CITY OF ALBUQUERQUE

April 16, 2018

RE: **Silver Star Auto Haus**
5111 Wilshire Ave. NE
Engineer's Stamp Date: 3/19/2018
Hydrology File: C17D014A1

# CONCEPTUAL GRADING & DRAINAGE PLAN

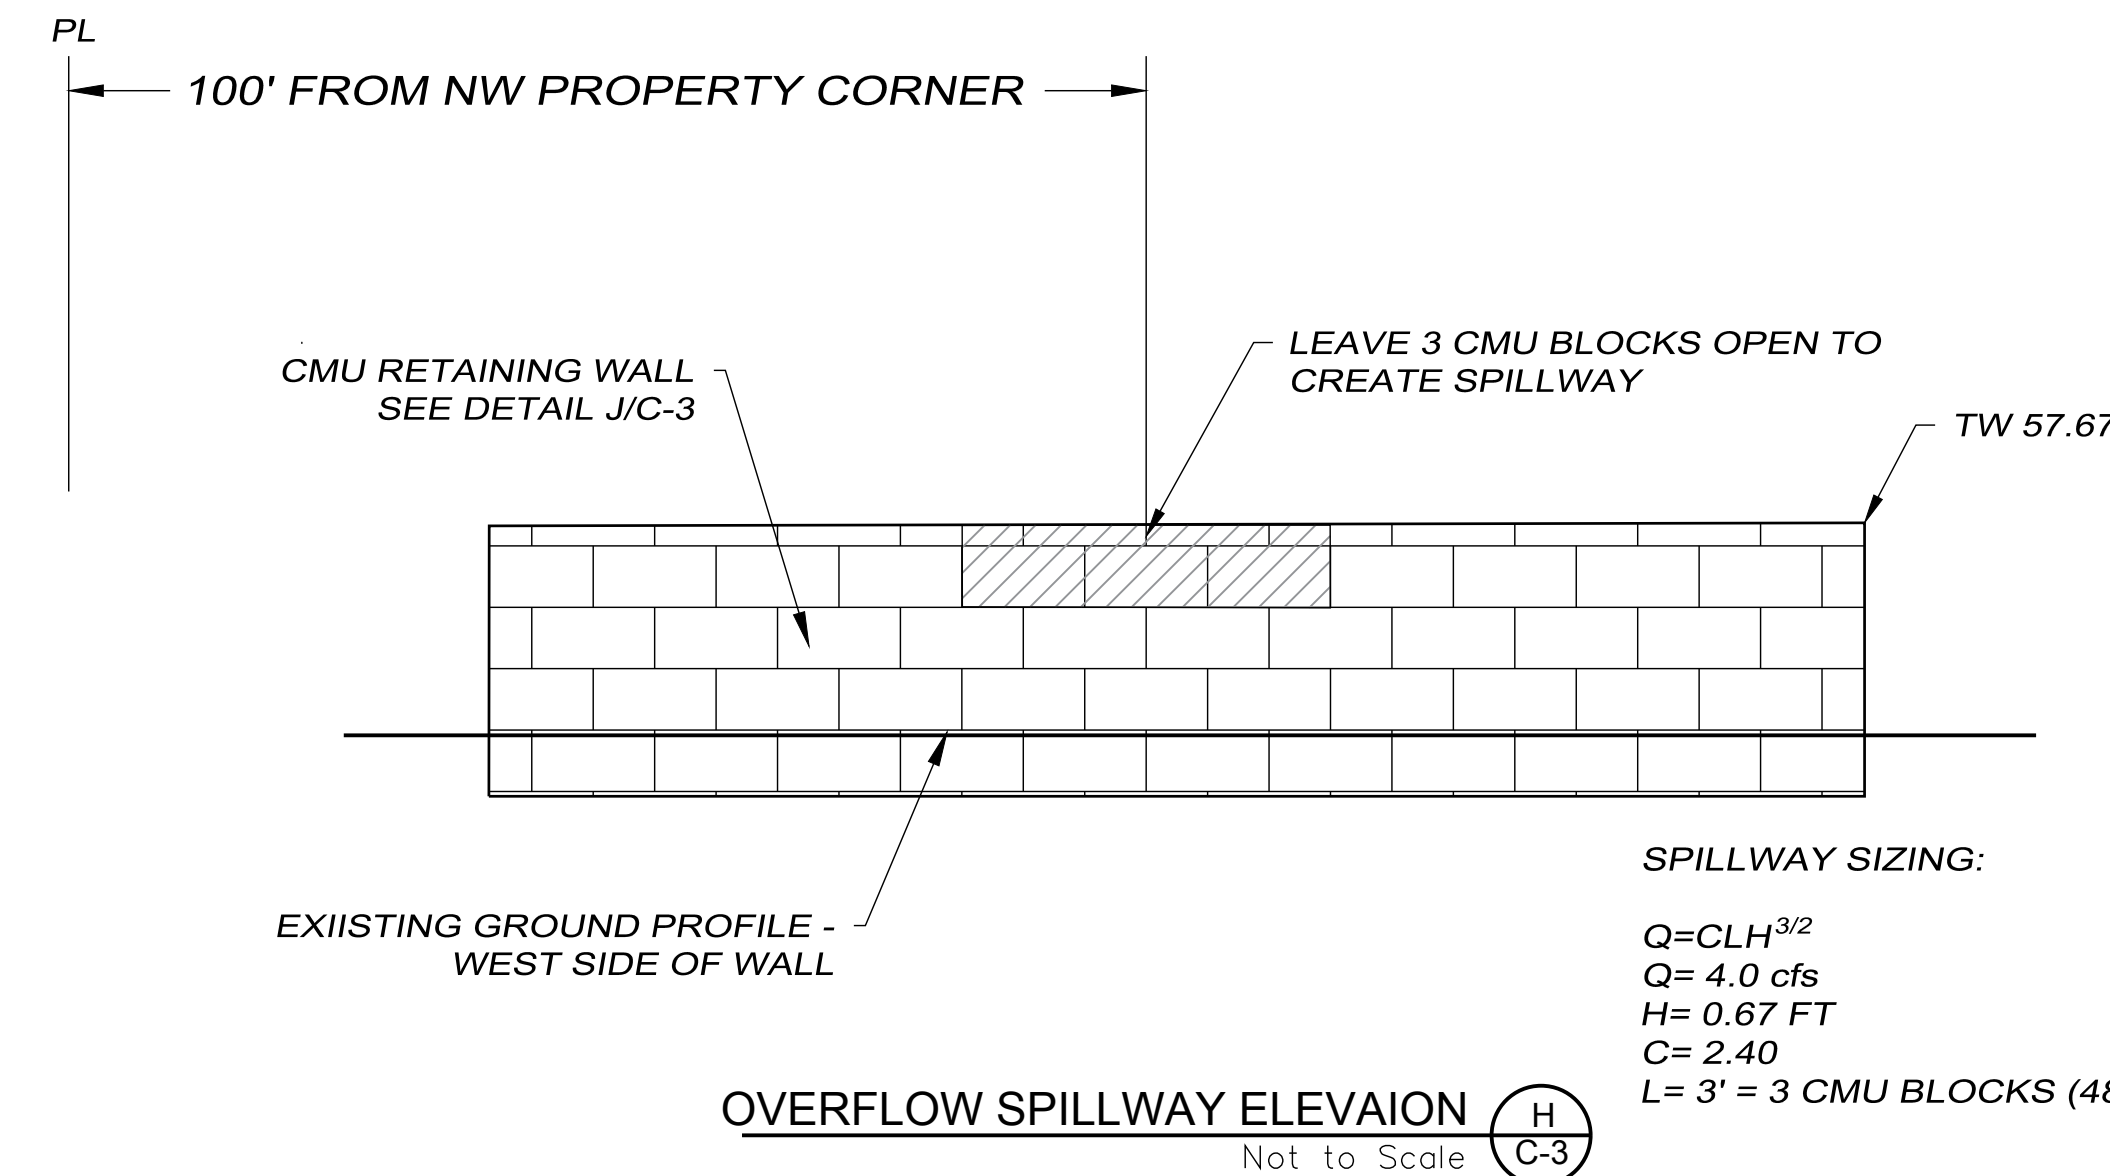
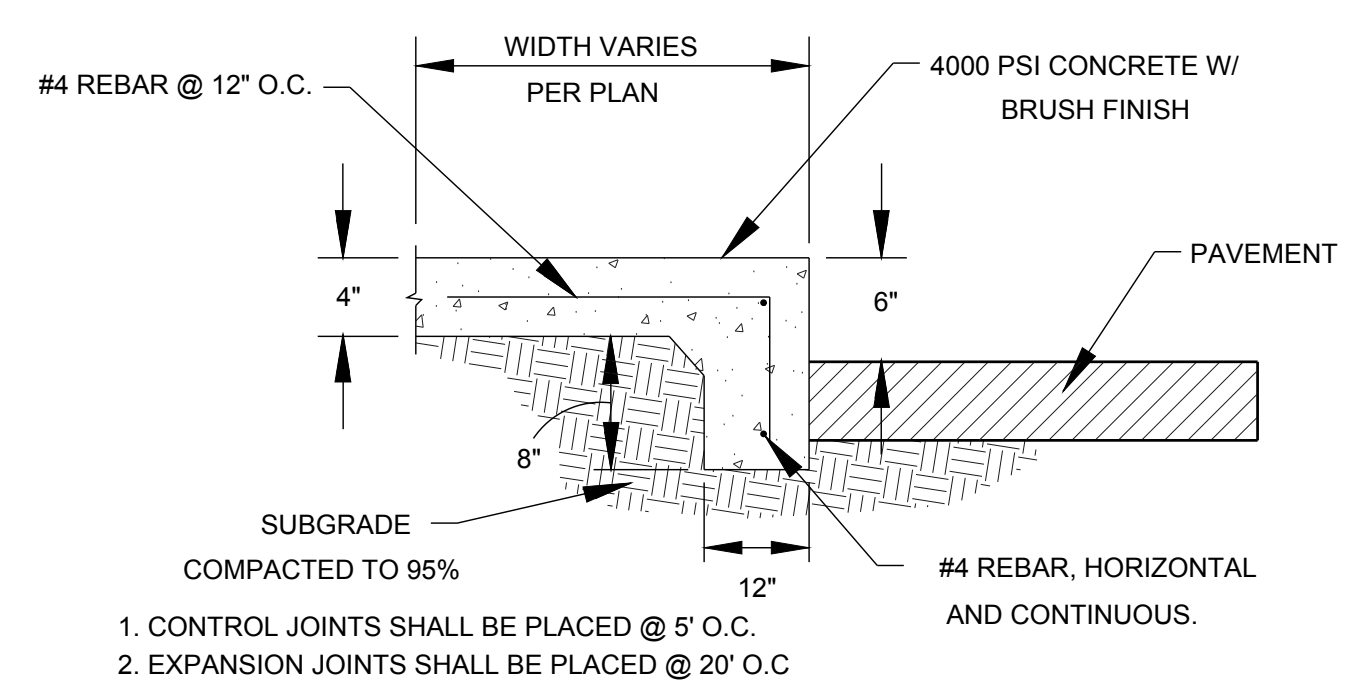
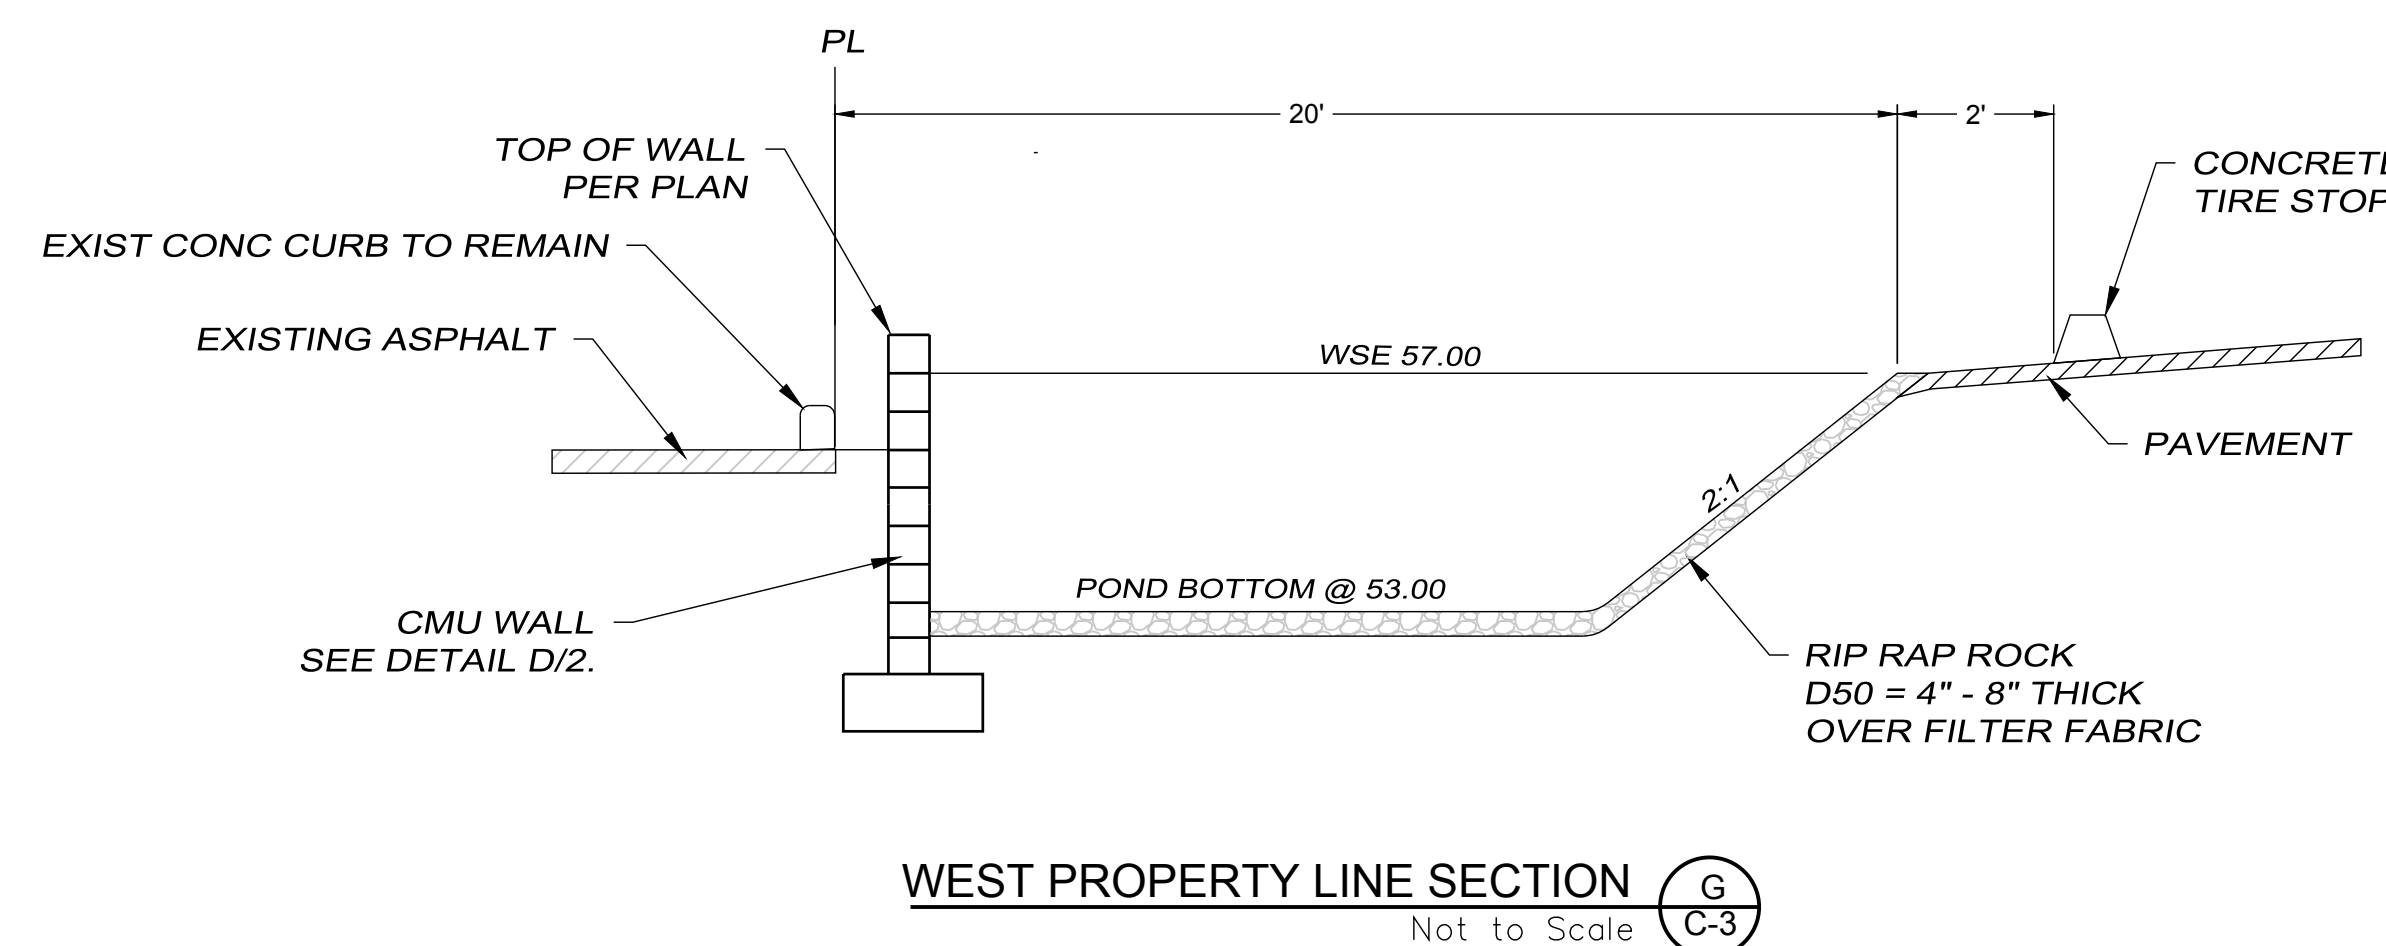
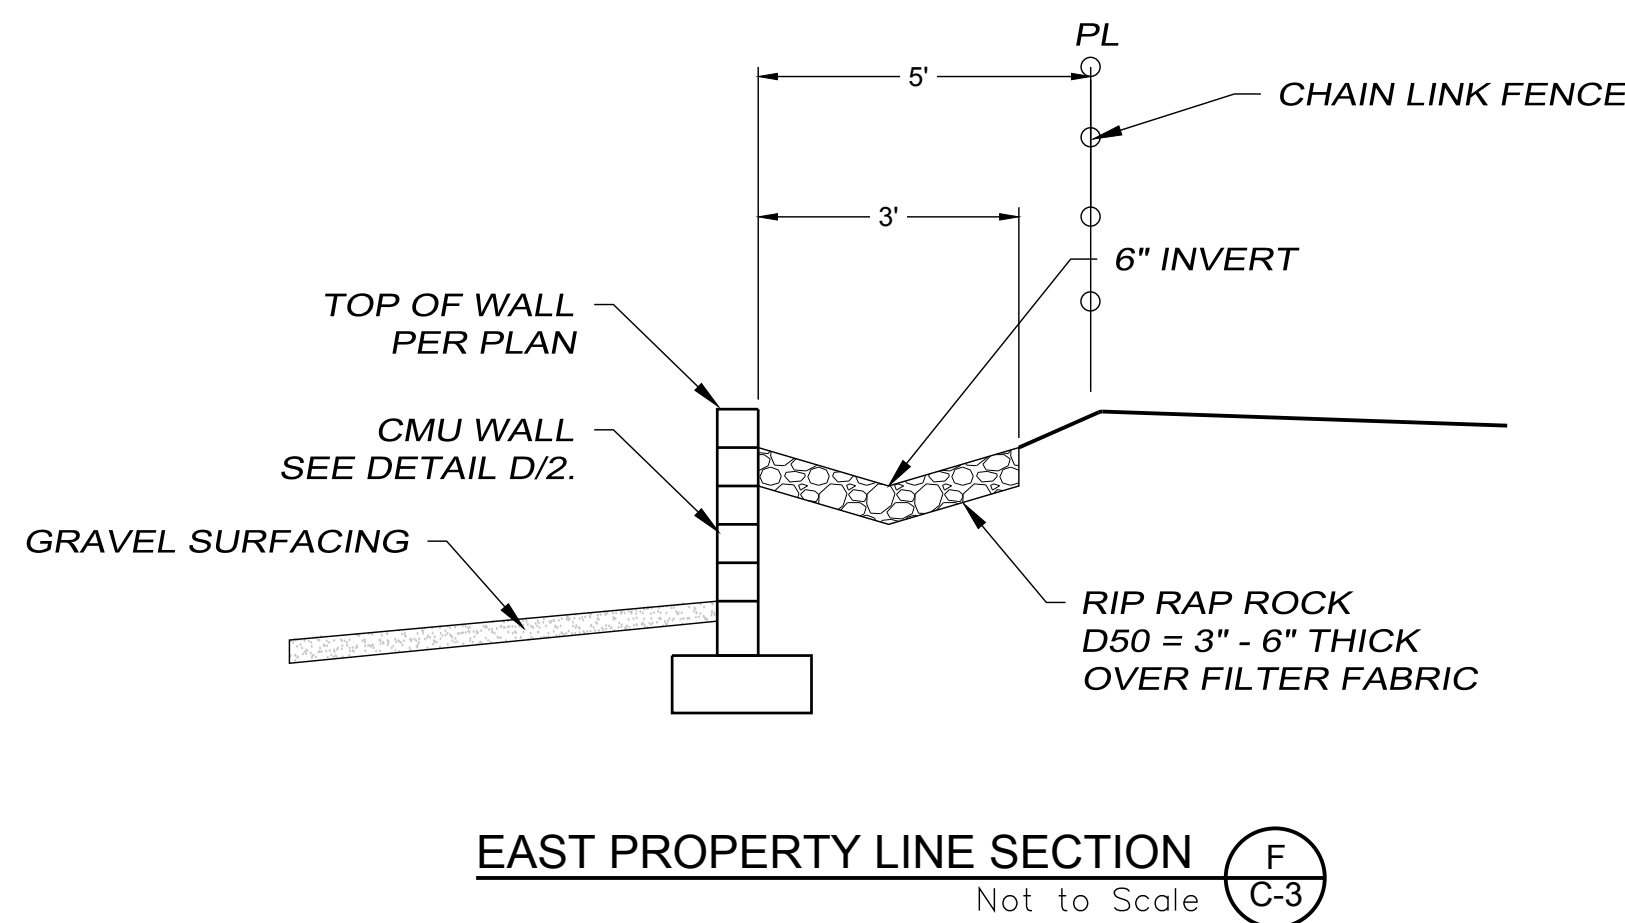
2. Add the words "see Notice to Contractor on sheet C-3" to keynote 28 on sheet C-2, and check the "SO-19 Approval" line on the DTIS.
3. Please consider moving the retaining walls away from the property lines to keep the footer out of the soil friction plain. Add a note on the plan view stating that "no encroachment is allowed into the neighbor's property without written permission and any damages to the neighbor's property must be repaired". Consider adding a requirement for piling and/or shoring of the taller cuts.

4. Pump specifications and performance curve are required. They should be added to the G&D Plan and the information should be included in the Drainage Covenant.
